CITY OF ALBUQUERQUE

June 26, 2020

Re: PowerCo Fitness Complex
1330 Cuesta Abajo
Traffic Circulation Layout
Architect's Stamp 06-19-20 (D16-D002F)

TRAFFIC CIRCULATION LAYOUT

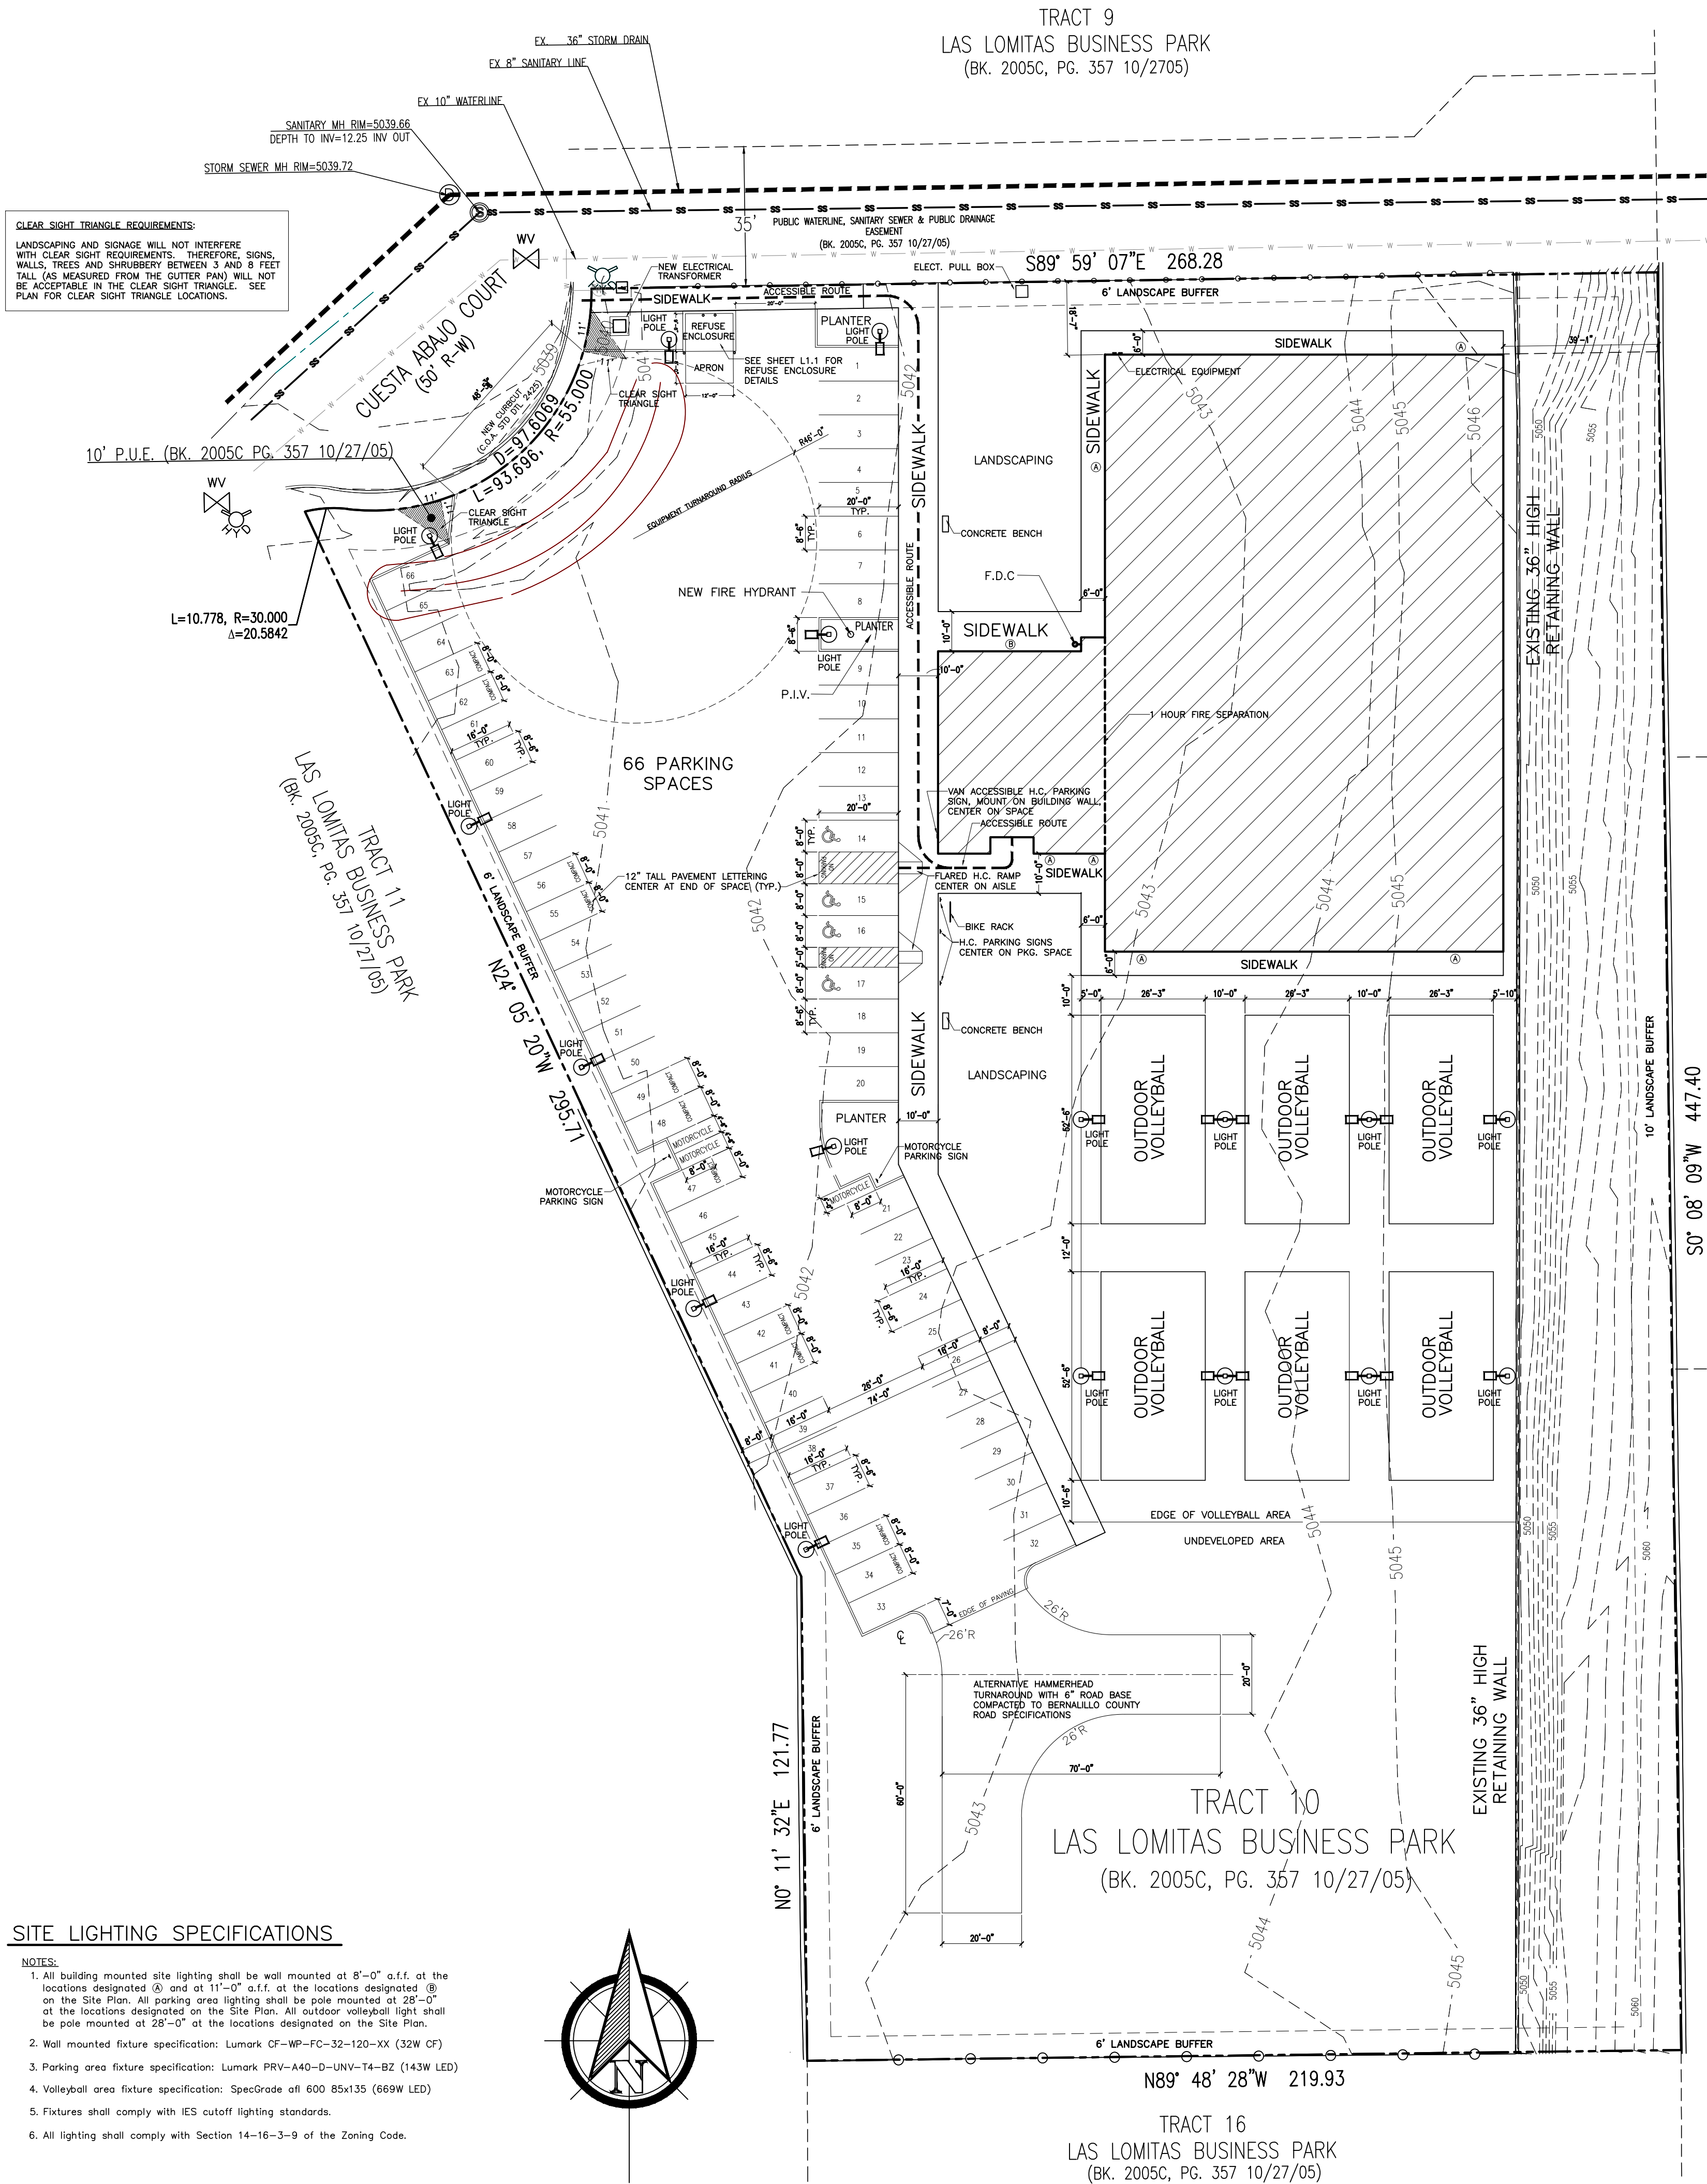
1. Please coordinate all calculations for parking spaces, including bicycle and motor cycle parking with Zoning and list the number required.
2. Please list the aisle widths. Some dimensions are not shown.
3. The minimum drive aisle width for two way traffic is 22ft, for Fire lane is 20 ft width.
4. **The minimum parking stall dimensions are:**

11. List radii for all curves shown; for passenger vehicles. Radius for **delivery trucks, fire trucks, etc.** is **25 ft. or larger**.
 12. Per the IDO, a 6 ft. wide ADA accessible pedestrian pathway is required from the public sidewalk to the building entrances. Please clearly **dimension this 6 ft** pathway. The parking stall overhang cannot impact the clear 6ft ADA pedestrian pathway.

13. Per DPM, a 6 ft. wide ADA accessible pedestrian pathway is required from the ADA parking stall access aisles to the building entrances. Otherwords, the ramp opening will need to be 6 ft in width per this

14. Refuse vehicle maneuvering shall be contained on-site. The refuse vehicle shall not back into the public right of way.; provide a copy of refuse approval. Verify this is the case.

15. The clear sight triangle will need to begin at back of curb and gutter.
 16. Provide a detail of entrance driveway because the proposed drivepad/driveway is very confusing drivepad. Why are constructing a 6 ft valley gutter where the ADA pedestrian pathway across driveway should be? This is very confusing, please address this concern.

17. Please specify the City Standard Drawing Number when applicable.
 18. Shared Site acces: driveways that straddle property lines, or are entirely on one property but are to be used by another property, shall have an access easement. Please include a copy of your shared access agreement with the adjacent property owner. **This applies to 6 ft landscape buffer, and existing 36 inch wall from adjacent property.**

BIKE RACK DETAIL 1/2" = 1'-0"

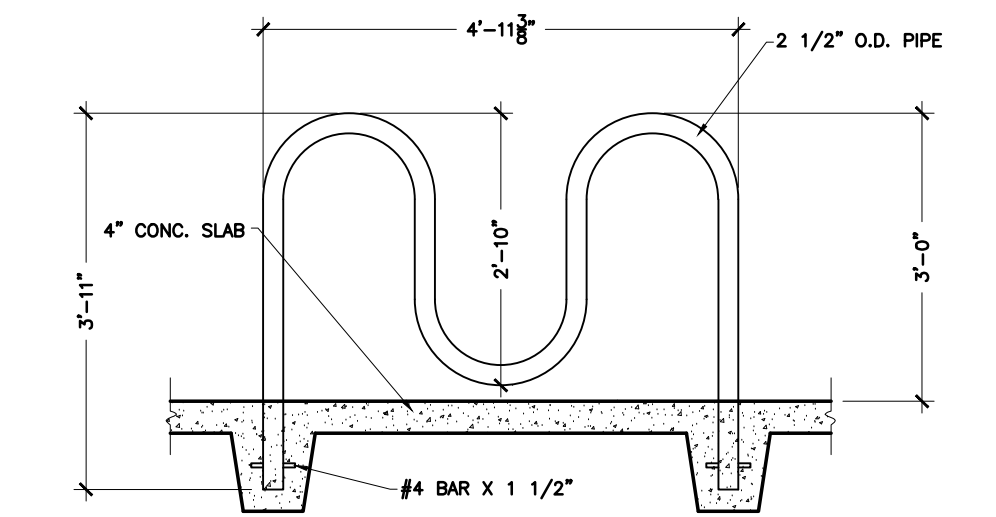
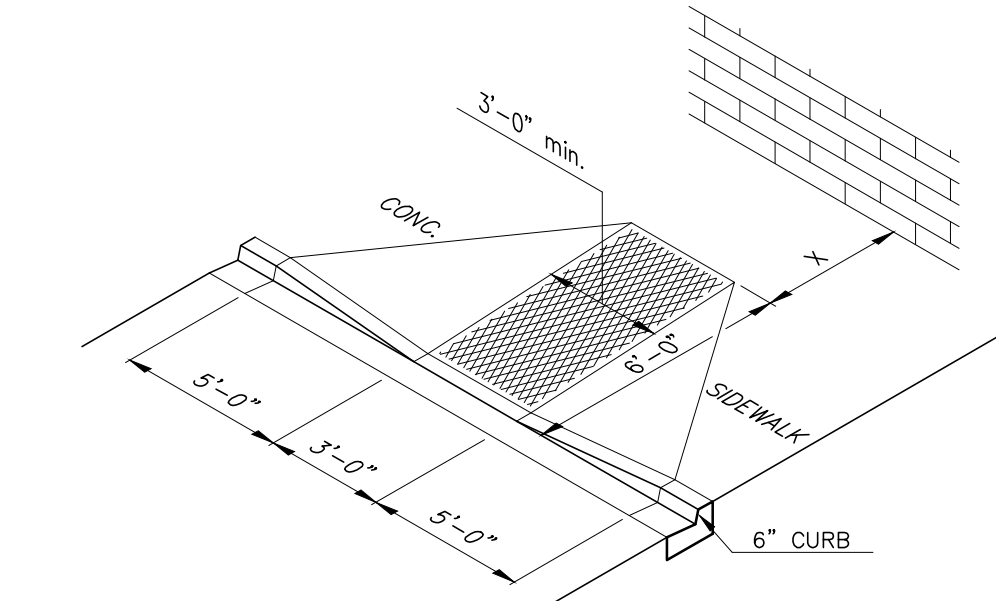
5. The ADA accessible parking sign must have the required language per 66-7-352.4C NMSA 1978 **"Violators Are Subject to a Fine and/or Towing."** Please call out detail and location of signs.
6. **Motorcycle parking spaces: Label pavement MC.**
7. All bicycle racks shall be designed according to the following guidelines (**Provide notes on site plan**):
 - a. The rack shall be a minimum 30 inches tall and 18 inches wide.
 - b. The bicycle frame shall be supported horizontally at two or more places. Comb/toaster racks are not allowed.

8. Bicycle racks shall be sturdy and anchored to a concrete pad.
 9. A 1-foot clear zone around the bicycle parking stall shall be provided.
 10. Bicycle parking spaces shall be at least 6 feet long and 2 feet wide.
